Consultation Response from: KC Environmental Health (Pollution & Noise Control)
2020/93527 - 6 Woodlea Avenue, Marsh, Huddersfield, HD3 4EF
Erection of cabin for business use (modified proposal)
**Date Responded:
01 December 2020**
**Responding Officer:
Mohammed Nasim**
**Responding Ref:
WK/202032218**
Comments

BLOCK PLAN (SHOWING PROPOSED)
Scale 1:200

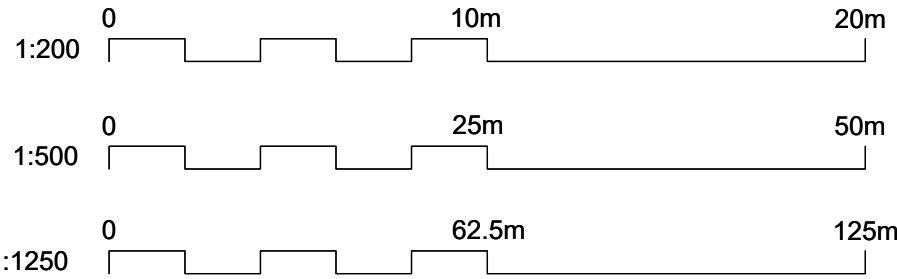
Reference is made to the feasibility of connecting the structure to the existing drainage system and this will need to be clarified as it is desirable to require the applicant to demonstrate that adequate provision for foul drainage is feasible before determining the application. A condition is recommended if this is the case.

It is understood that a mains drainage system is not available for the development. No detailed information has been provided regarding the proposals for providing an adequate system of foul water drainage which will be required by the building regulations. To ensure that it is feasible for the building regulations to be met and also avoid the possible need for a further planning application relating to the construction of a septic tank it is recommended that

before determining the application the applicant provides detailed information to show how a satisfactory foul drainage system is to be provided for the proposed development. The submitted information needs to demonstrate that the requirements of The Building Regulations 2010 Approved Document H, Drainage and Waste Disposal can be met and if a small sewage treatment plant (i.e. septic tank or package treatment plant) is proposed that the “General binding rules for small sewage discharges” can also be met. The details must therefore include the following information:

- a) The location of the tank (which must not be so near to any inhabited building as to be liable to become a danger to health or a source of nuisance (a minimum of 7m is required but over 20m and down slope is preferable) or in an area where there is a risk of flooding)

- b) The discharge details for the tank (which must not present any risk of contamination to any watercourse, underground water or drinking water supply)

- c) Details showing how adequate means of vehicular access will be provided to allow the tank to be periodically emptied and maintained
- d) Calculations demonstrating that the tank will be of adequate capacity for the highest number of persons that may use the tank
